Application by Riveroak For An Order Granting Development Consent For An Airport At Manston Airfield

Application Ref: TR020002

Response to the Examining Authority's FOURTH Written Questions by the Historic Buildings and Monuments Commission for England (Historic England)

Dated: 27 June 2019

Figure 9.4
Built heritage assets within the site boundary

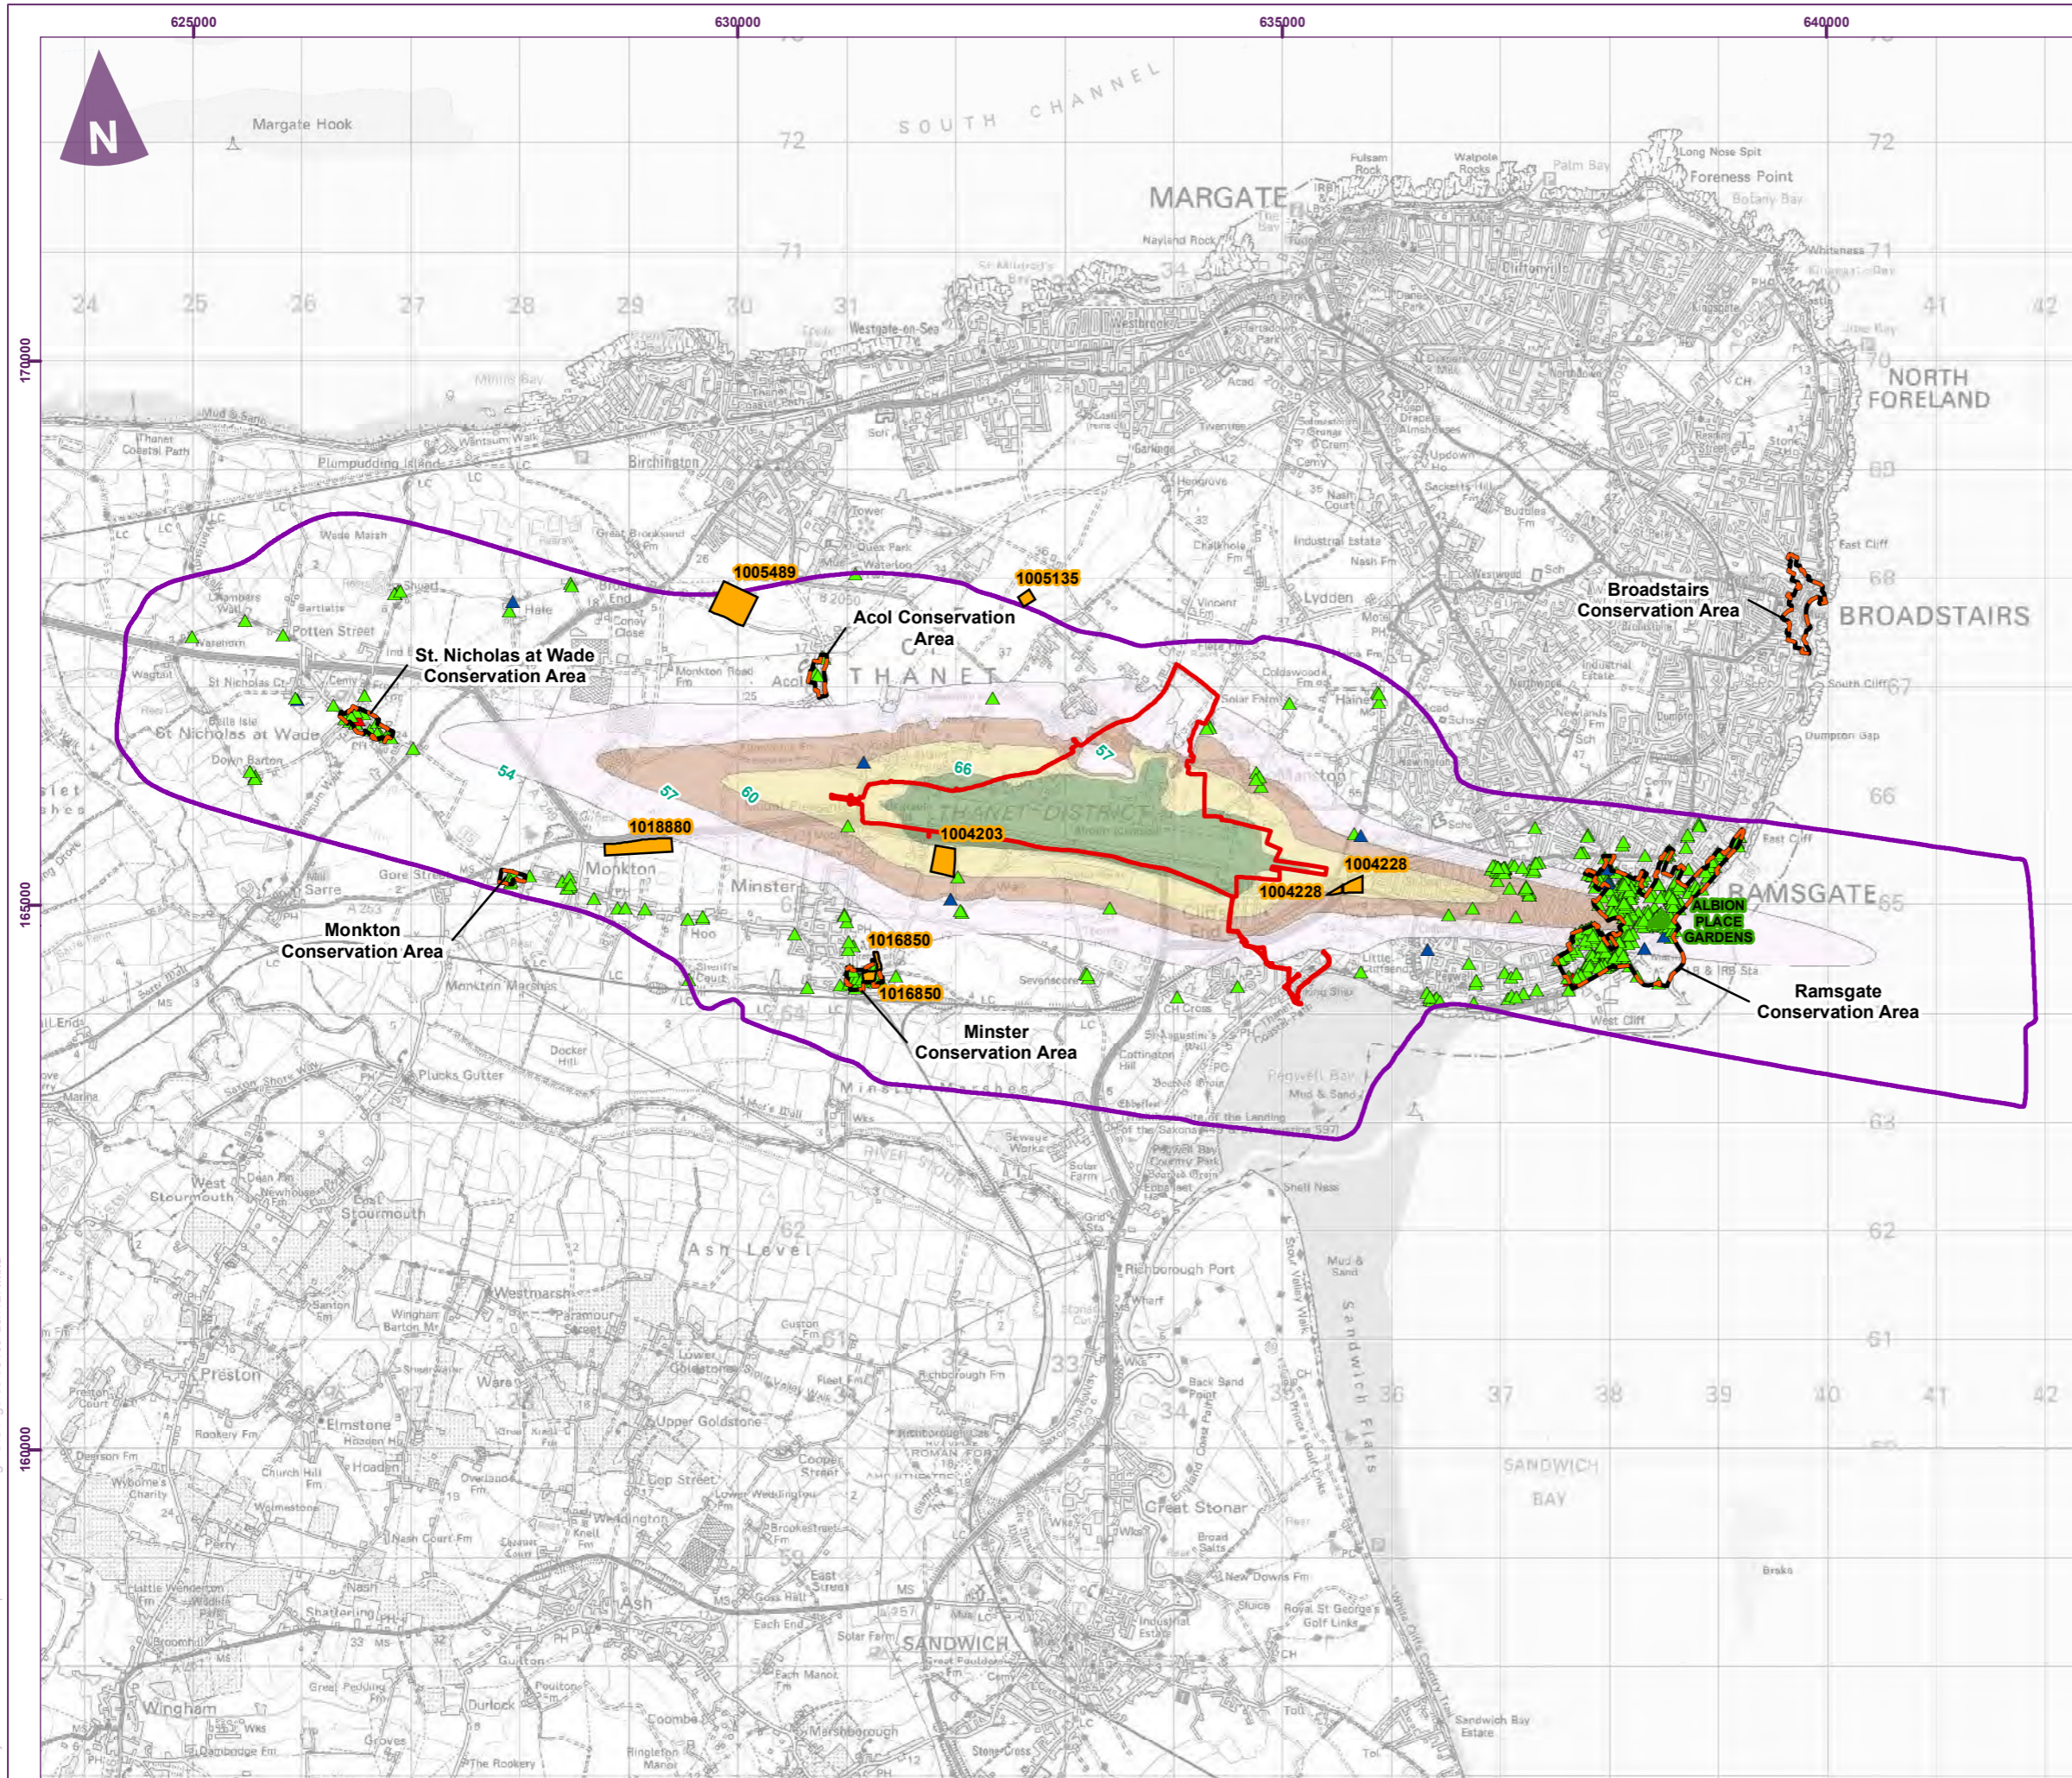
2.1. The ExA requested comments on the justification for the proposed removal of the T2 Hangar and WWII Dispersal Bay.

2.2. It remains Historic England’s view that no clear and convincing justification has been offered for the removal of the T2 Hangar and WWII Dispersal Bay and that survey and assessment are necessary. We have had no further discussion with the applicant on this subject.
